DELEGATED HOUSEHOLDER DECISION

Item No. Report of the Head of Development Management and Building Control**Address:** 30 STATION APPROACH SOUTH RUISLIP**Development:** Installation of dropped kerb.**LBH Ref Nos:** 69472/APP/2025/2500**Drawing Nos:** PL-01
PL-02 - Rev A
PL-03 - Rev A**Date Plans received:** 26-09-25 **Date(s) of Amendments(s):** 26-09-25**Date Application valid** 30-09-25 06-11-25

Proposed Drop Kerb Plan

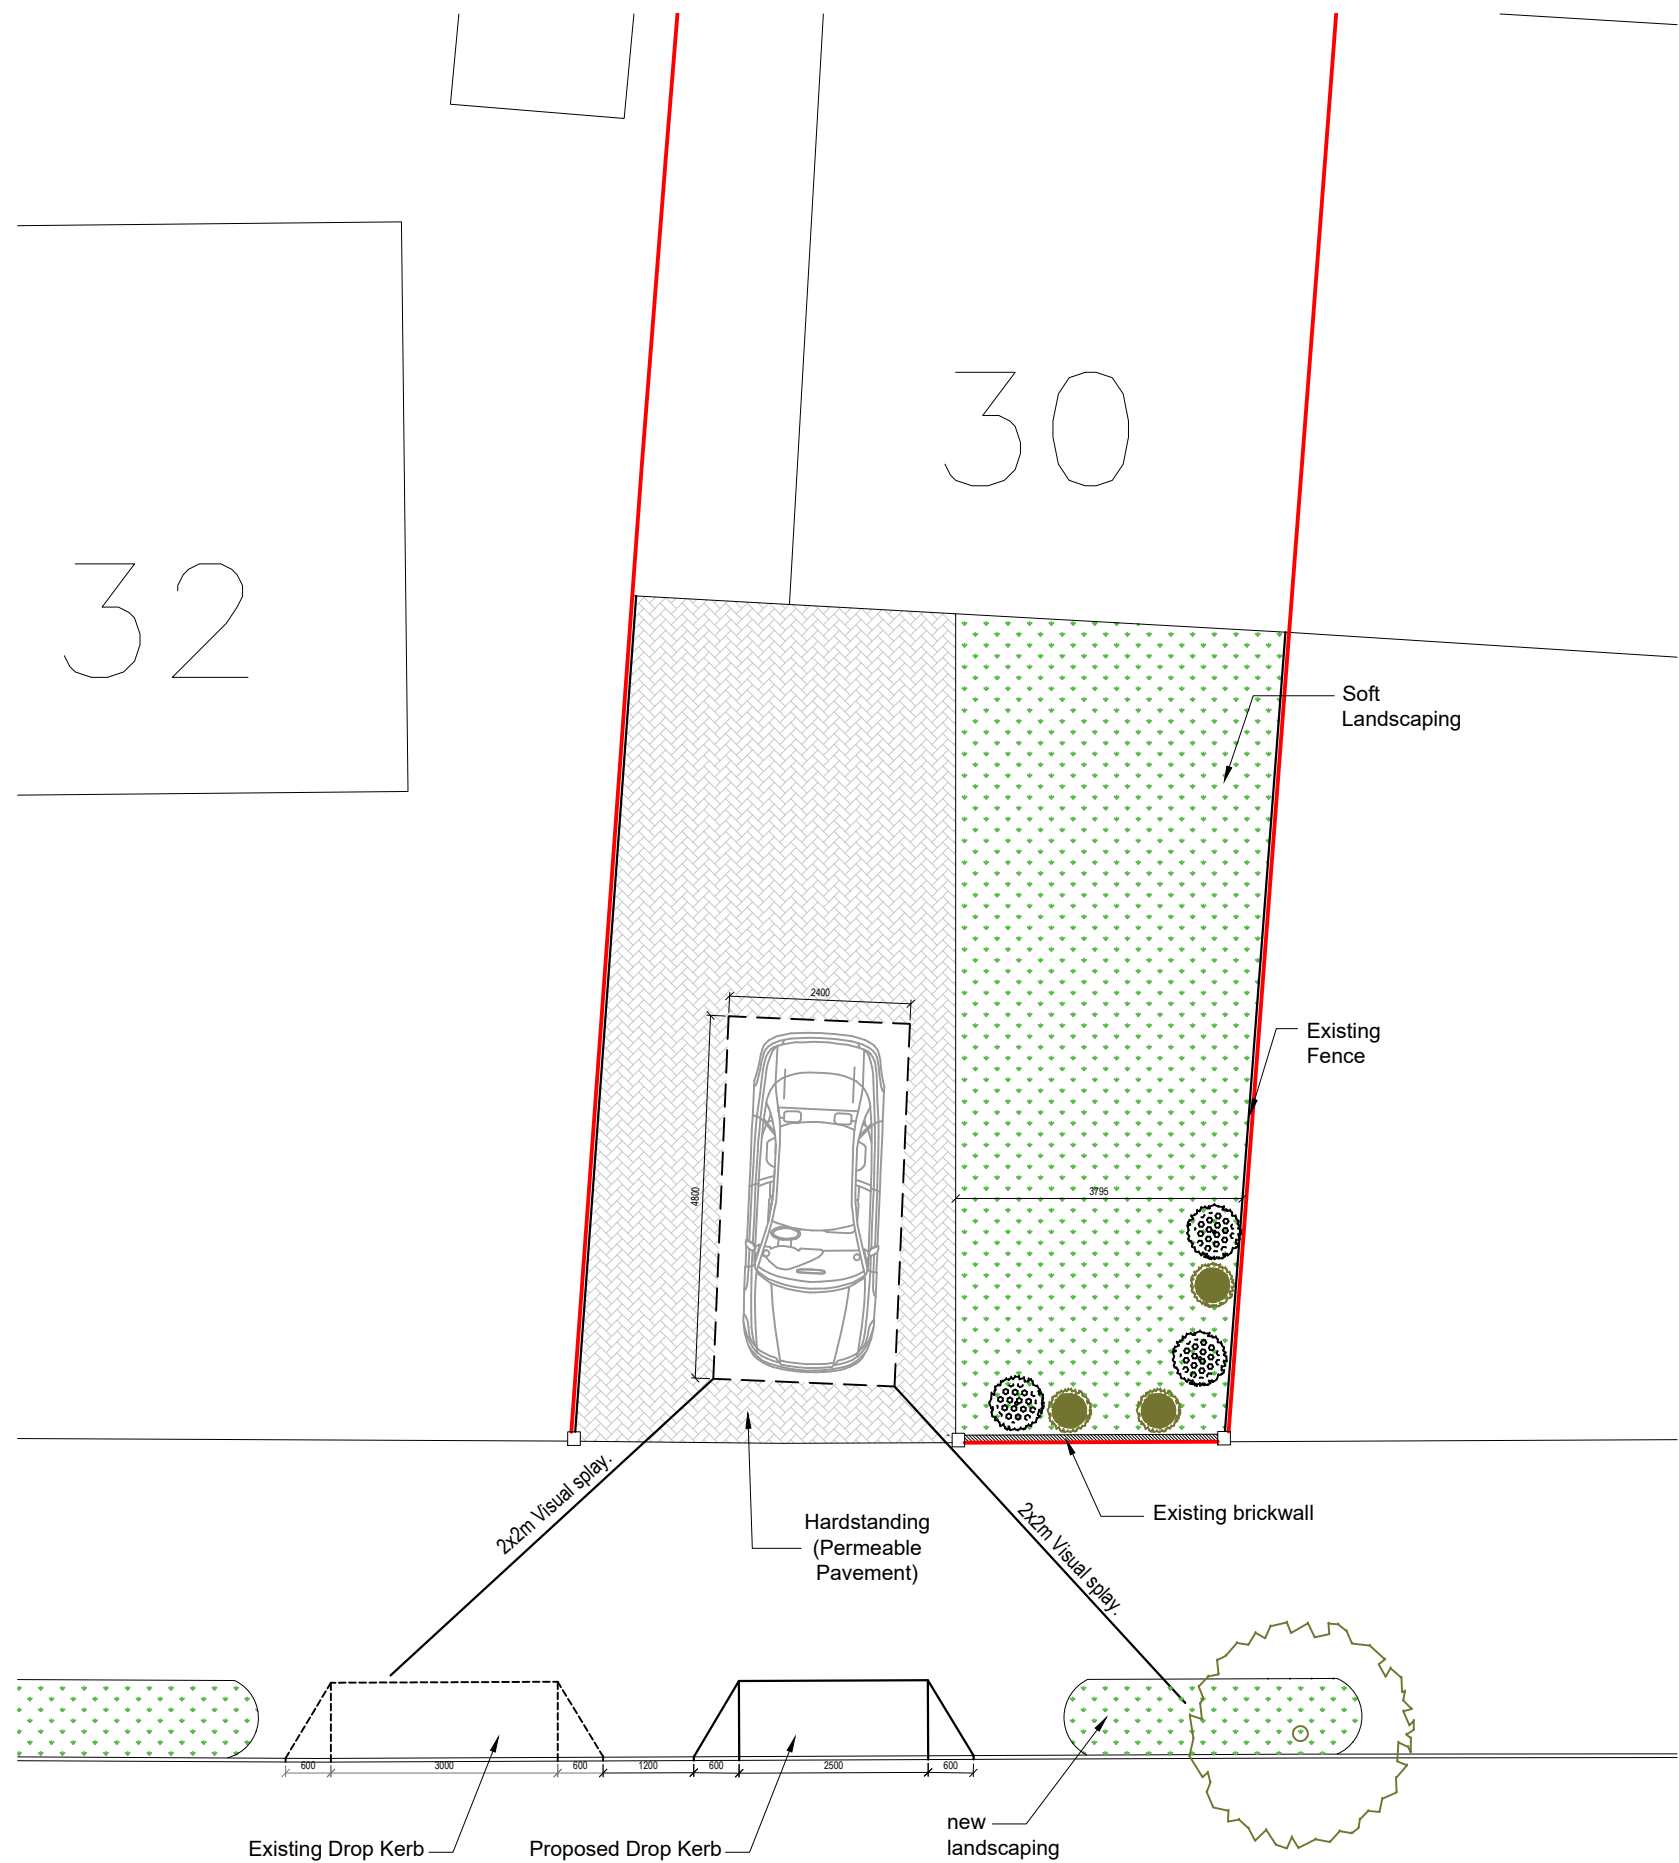
Planning permission is sought for the installation of a dropped kerb. The original submission proposed an extension to the dropped kerb of the neighbouring property at No. 32 Station Approach. The scheme was amended in accordance with comments received from the Highways Authority to ensure that only land within the Applicant's ownership was impacted by the proposed development.

Hillingdon Council's Highways Authority reviewed the application and are satisfied that the proposal would not present a risk to road safety, hinder the free flow of traffic or lead to parking stress. They have requested that all fences, walls and shrubs within these areas are to be kept to a maximum height of 0.6m. This will be conditioned on the final decision notice.

The access for the car parking hereby approved shall be provided with 2.4m x 2.4m pedestrian visibility splays and shall be maintained free of all obstacles between heights of 0.6m and 2.0m above the level of the adjoining highway.
